RE: Weston Lodge, 39 Brook End, Weston Turville – Application for a s73 Amendment to Planning Permission Ref: 22/01925/APP

Please find attached an application made under section 73 of The Town and Country Planning Act 1990 (as amended) seeking to vary planning consent Reference 22/01925/APP, Condition 2 – Approved Drawings and Condition 3 – Materials (as indicated).

Drawing: Revised Fenestration & Materials

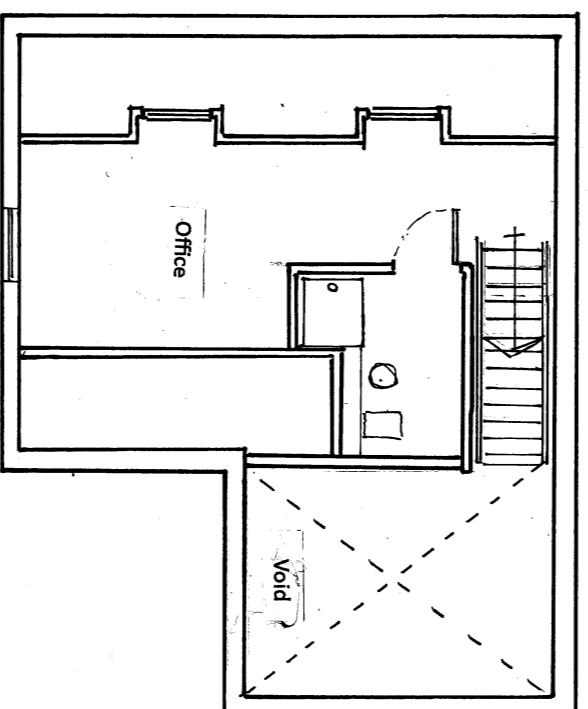
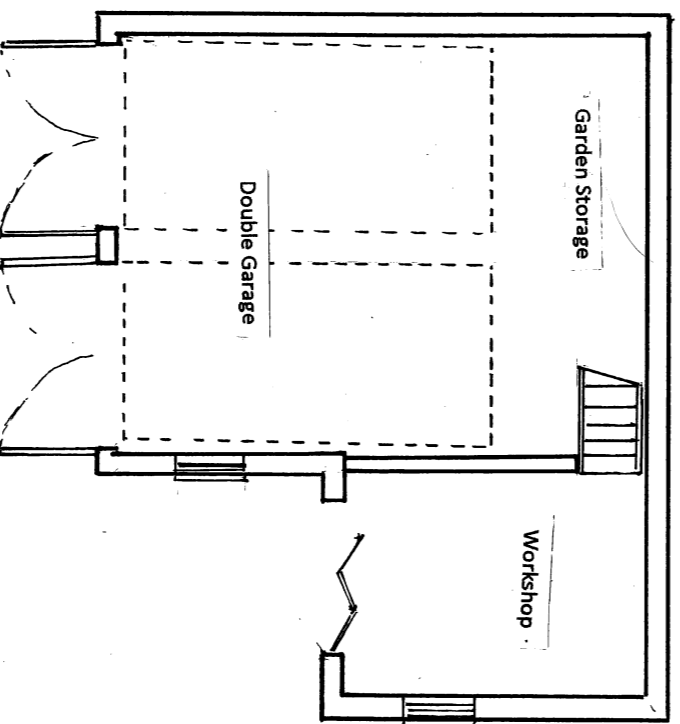
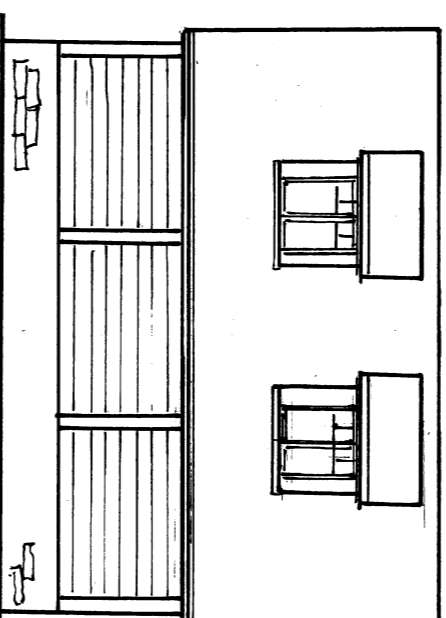
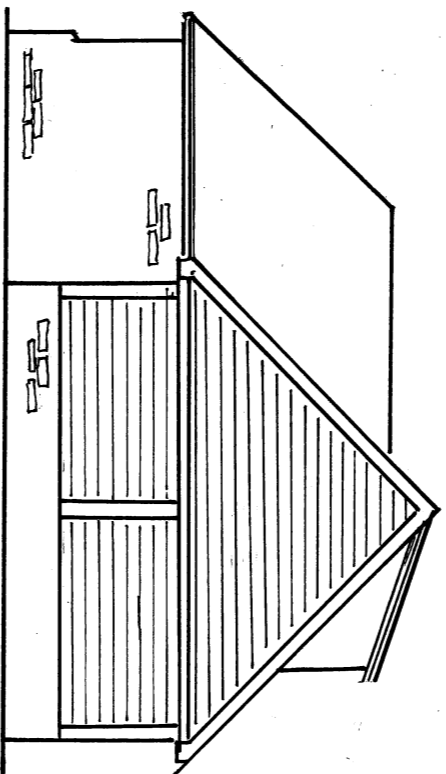
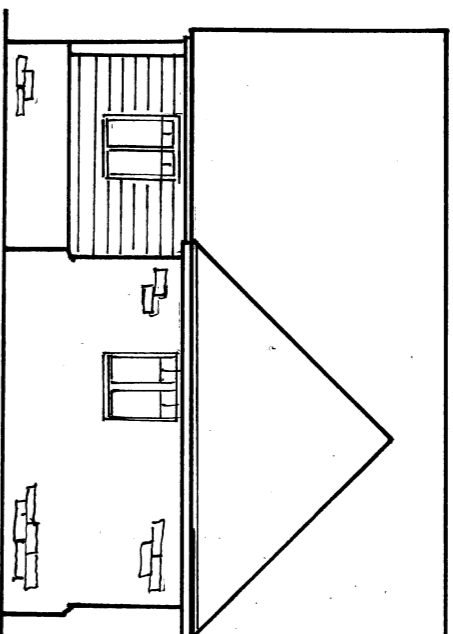
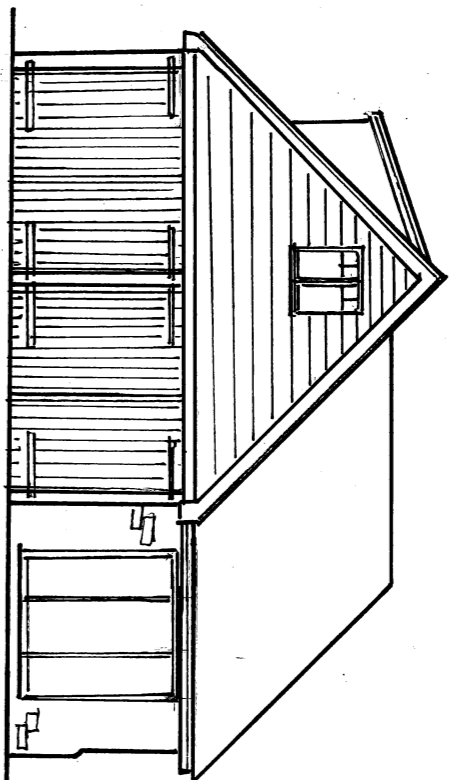
On the south-west elevation of the workshop, one of the two approved windows will be omitted. On the north-west elevation of the workshop, instead of the door and window as approved, a single cart style (glazed) opening will be inserted.

Instead of the approved timber cladding above the brick plinth, the external walls of the workshop will be entirely of the approved bricks (red multi).

Due to a south facing window being omitted, the required extent of natural light will instead be provided by a single glazed opening in the north elevation of the workshop (away from neighbouring property), which will replace the approved door and window. This revision has been designed to appear as a simple traditional 'cart style' opening with black timber framing which will appear recessive.
